**RE: 6/2016/2675/MAJ - Queenswood School, Shepherds Way, Brookmans Park, AL9 6NS**

Thank you for consulting us on the application above for the demolition of the existing Sports Hall and construction of a new enlarged facility including the re-cladding of existing roof and wall, following removal of existing mobile classrooms and increase parking provision from 85 to 102 approximately, at Queenswood School, Shepherds Way, Brookmans Park, AL9 6NS.

We understand this application seeks full planning permission for a major development, and we are happy to find Flood Risk Assessment And Surface Water Drainage/ SuDS Strategy prepared by Evans Rivers and Coastal Ltd with reference: 1731/RE/11-16/01 and dated November 2016 in support to this application. However this does not provide a suitable basis for assessment to be made of the flood risks arising from the proposed development.

Title  
**PROPOSED SURFACE WATER  
AND EXCEEDANCE EVENT AREAS**

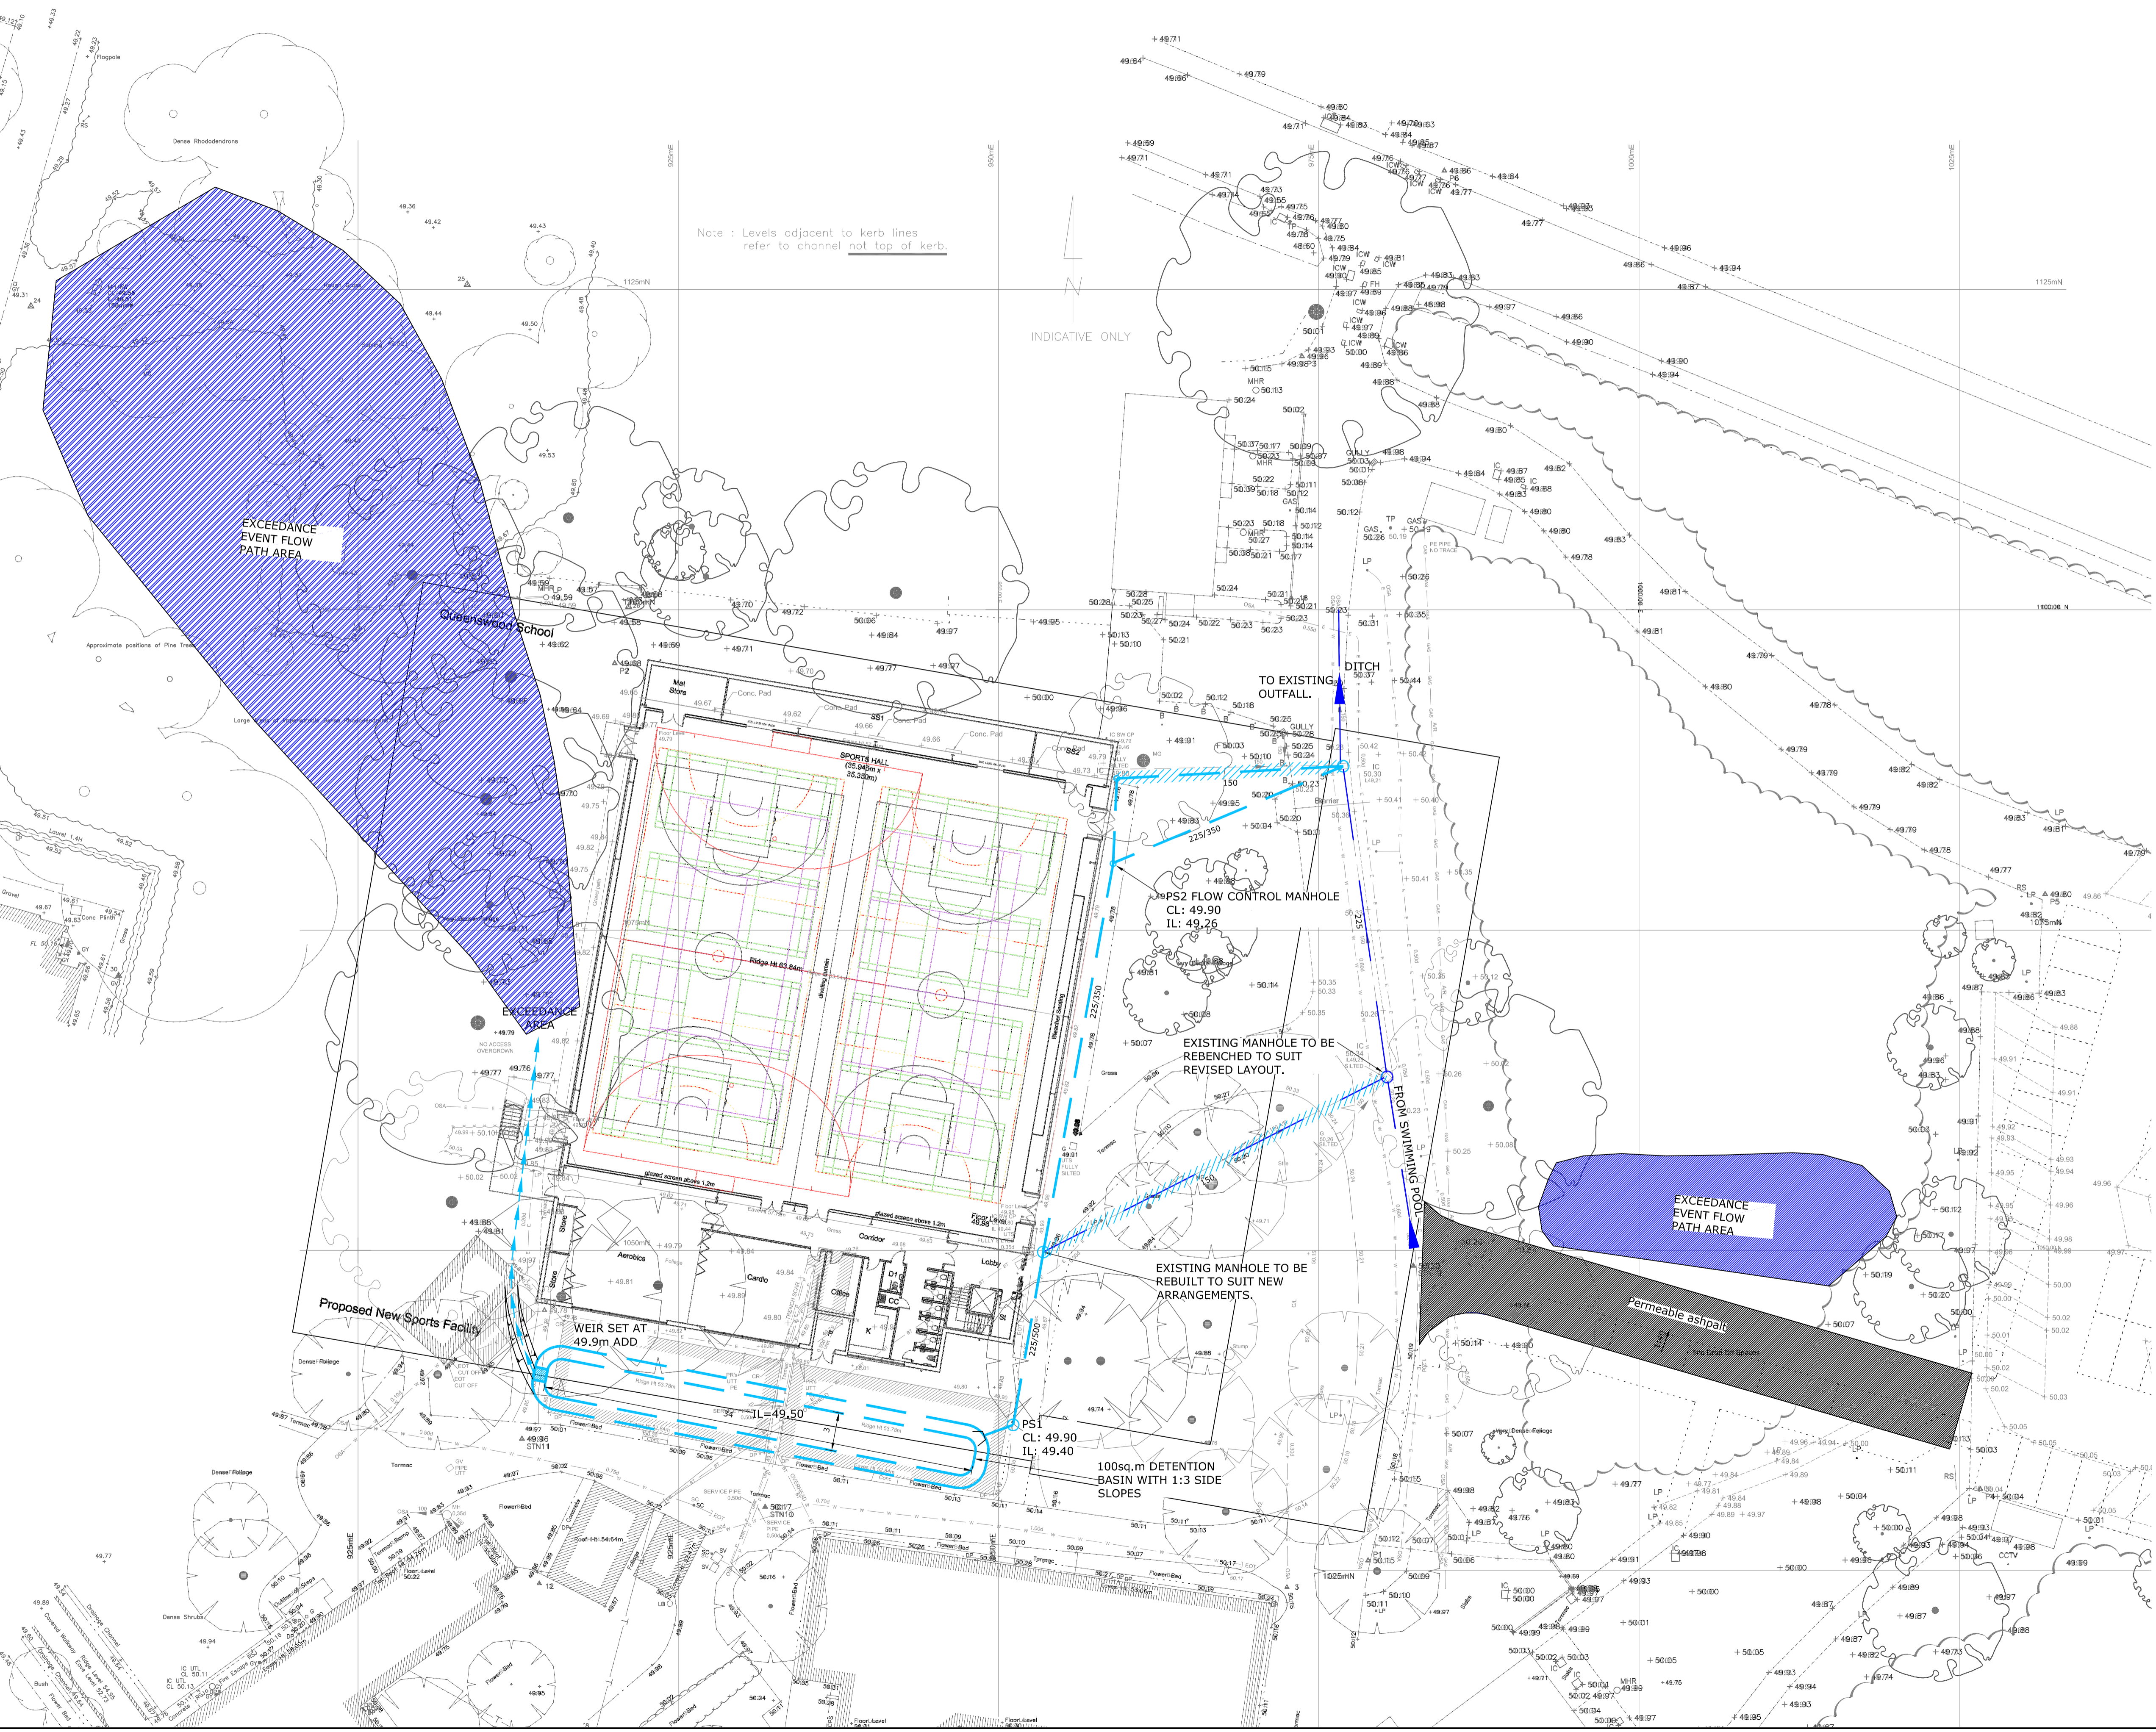
2. Detailed layout of existing/proposed surface water storage drainage including the location of all SuDS features, pipe runs and existing surface water features overlain on the development layout along with all the corresponding detailed calculations. The drawing named SUDS Strategy produced by Evans Rivers and Coastal Ltd under the project number 1731/RE/11-16/01 does not provide suitable details.

- 5/6. We would like to remind the applicant that exceedance flow paths for surface water should be calculated for events greater than the 1 in 100 year plus 40% of climate change event. In addition any exceedance routes proposed for flood management on the site should be shown on a plan. The FRA should also include full detailed engineering drawings for flood mitigation and management measures.
